**Town & Country Planning Act 1990 (as amended)
Town and Country Planning (Development Management Procedure) (England) Order 2015
Application for Planning Permission**

Development Demolition of 4 No. existing bungalows & erection of 5 No. 2 bedroom dwellings with associated parking & landscape.

Location 1-7 Canada Road Arundel

Block Plan Amend

Site Plan 1:200

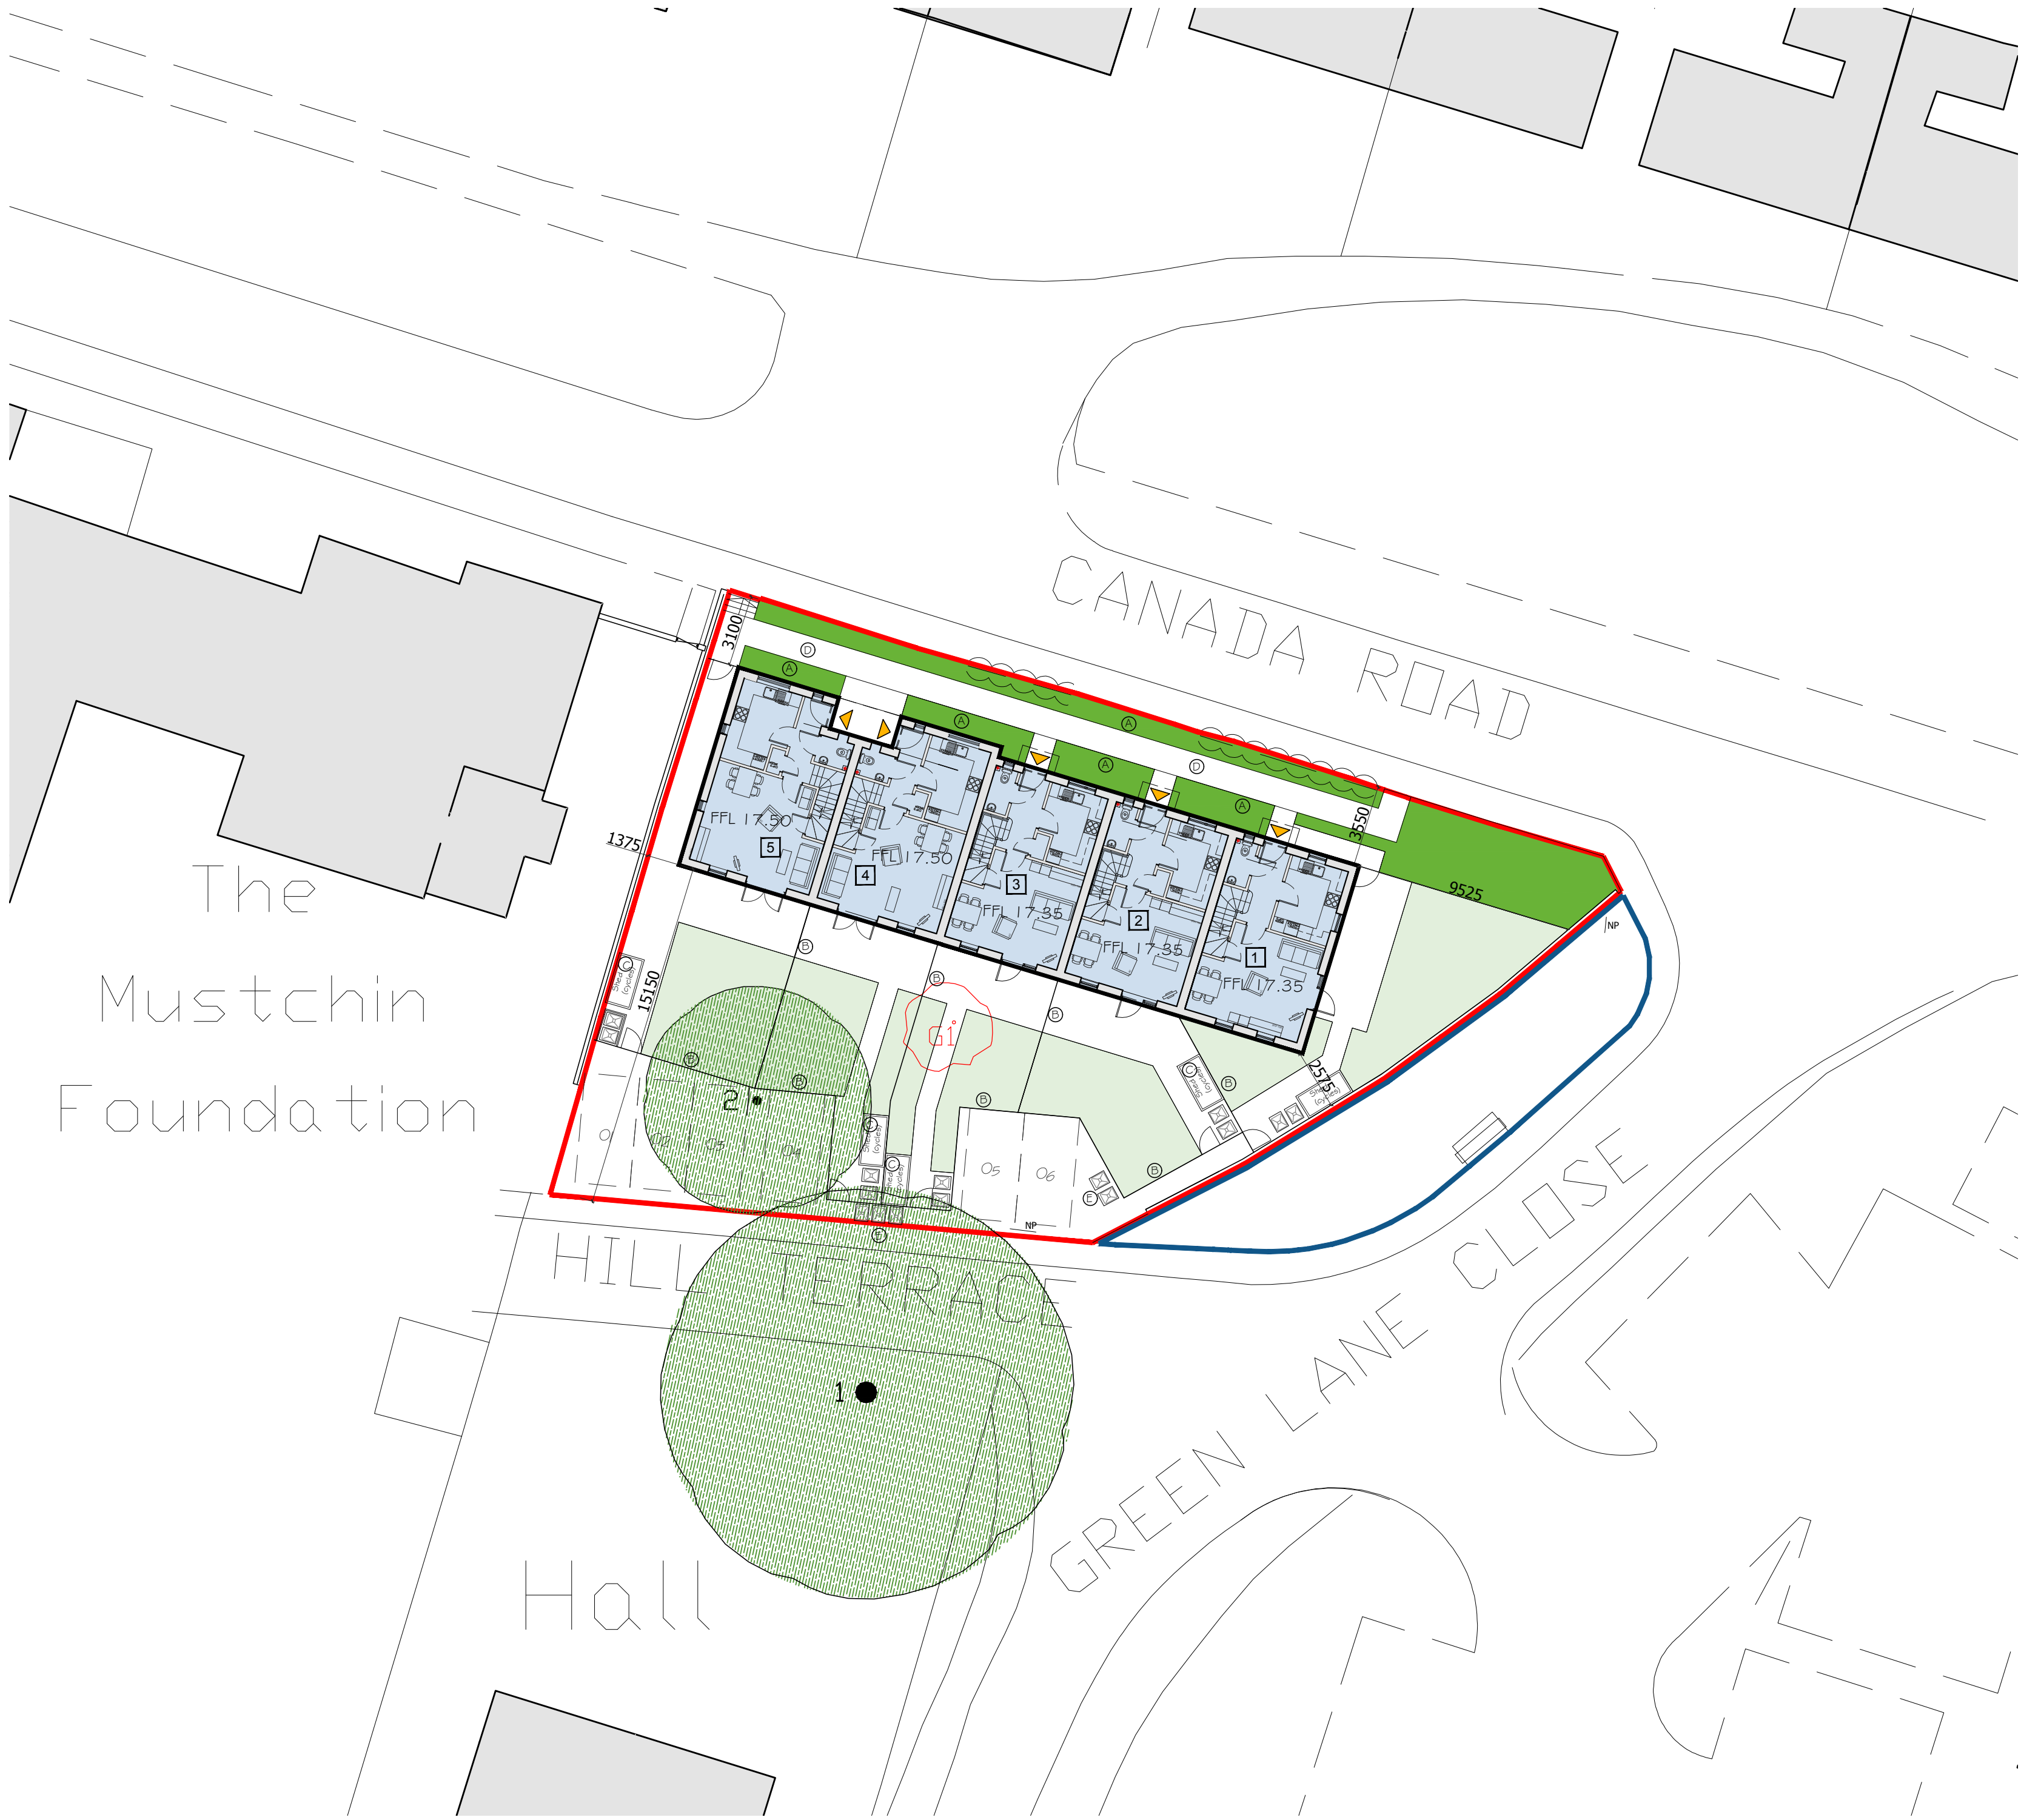
Please submit 1 electronic or 3 paper copies of a block/site plan at a scale of 1:500 or 1:200. Further details of what must be included on the plan can be found in the National Validation Requirements. Please provide measurements from the proposal to the site boundaries.

Cycle shed plan and elevations

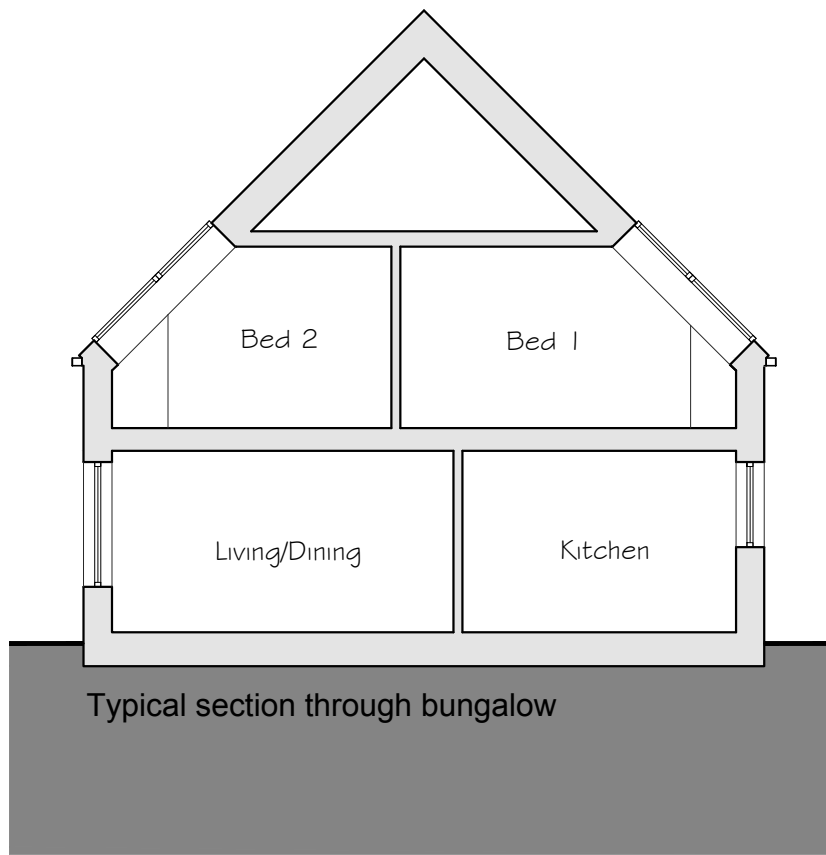
Please provide floor plans and elevations for the proposed cycle sheds.
